Ribble Valley Borough Council

App no: 3.2026.0346

Address: Ground floor Unit 6 Abbey Works King Street Whalley

Proposal: Regularisation of change of use of ground floor to indoor sport and recreation (Class E (d))

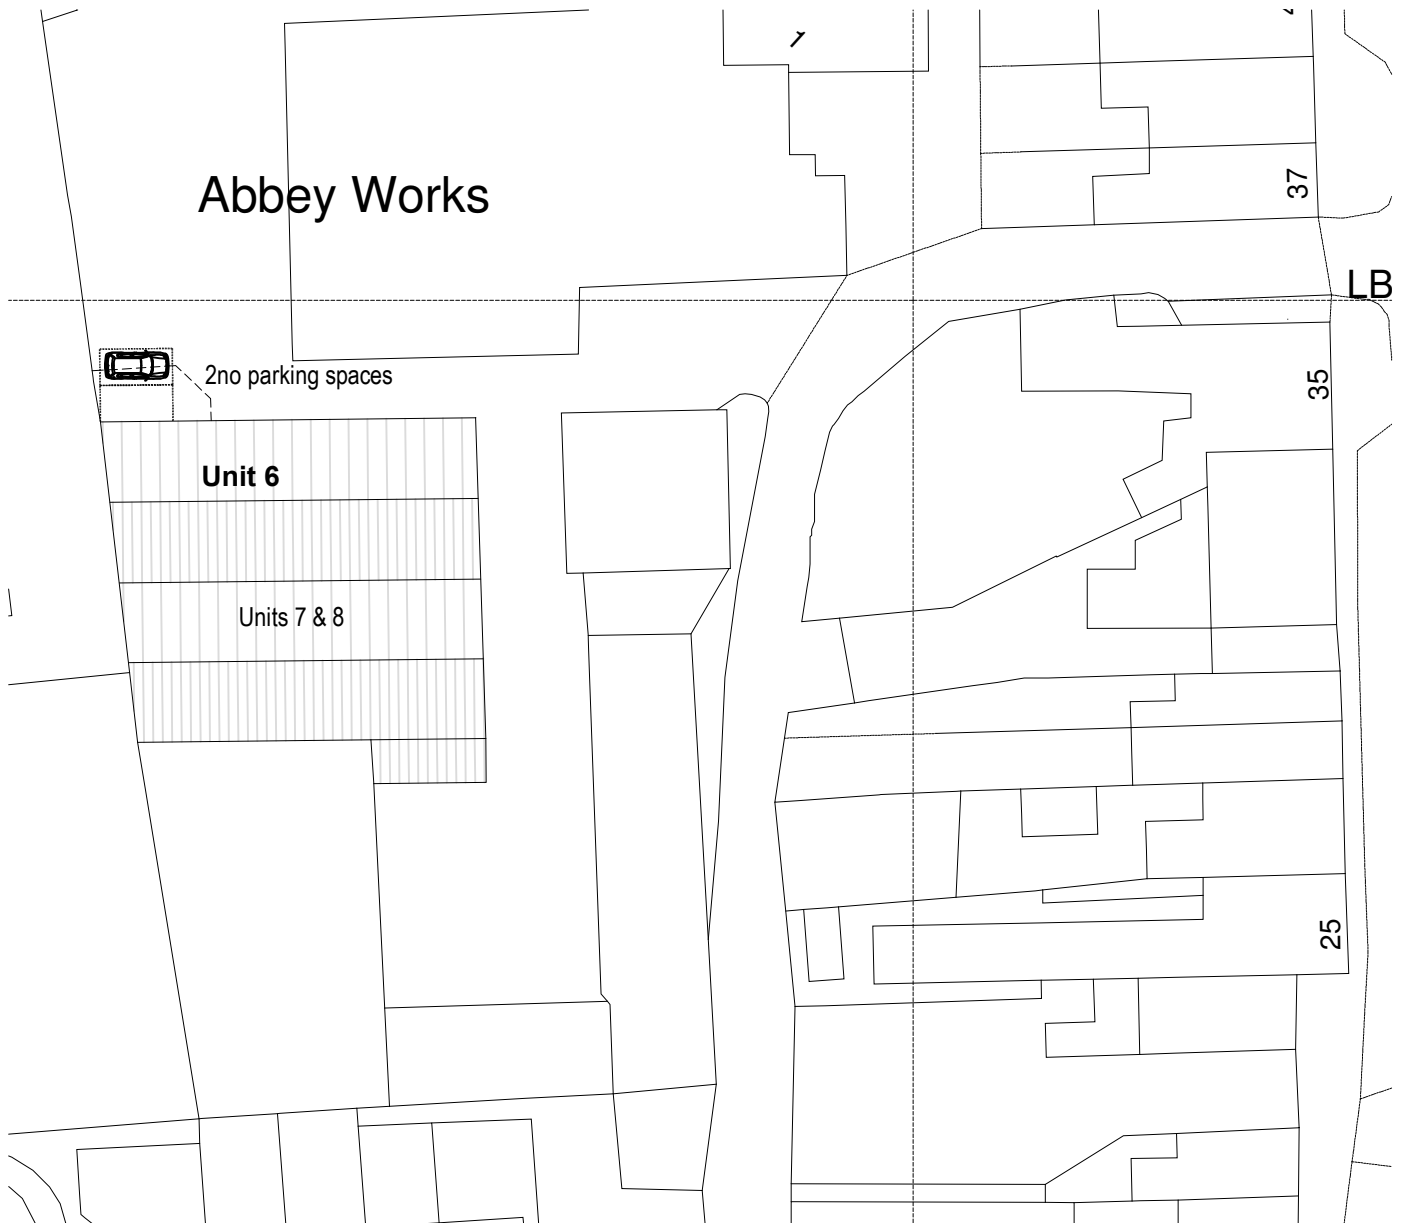
There are 2 car parking spaces proposed to be provided.

The proposed use would intensify the car parking demand significantly and further information is requested to demonstrate how this will be managed.
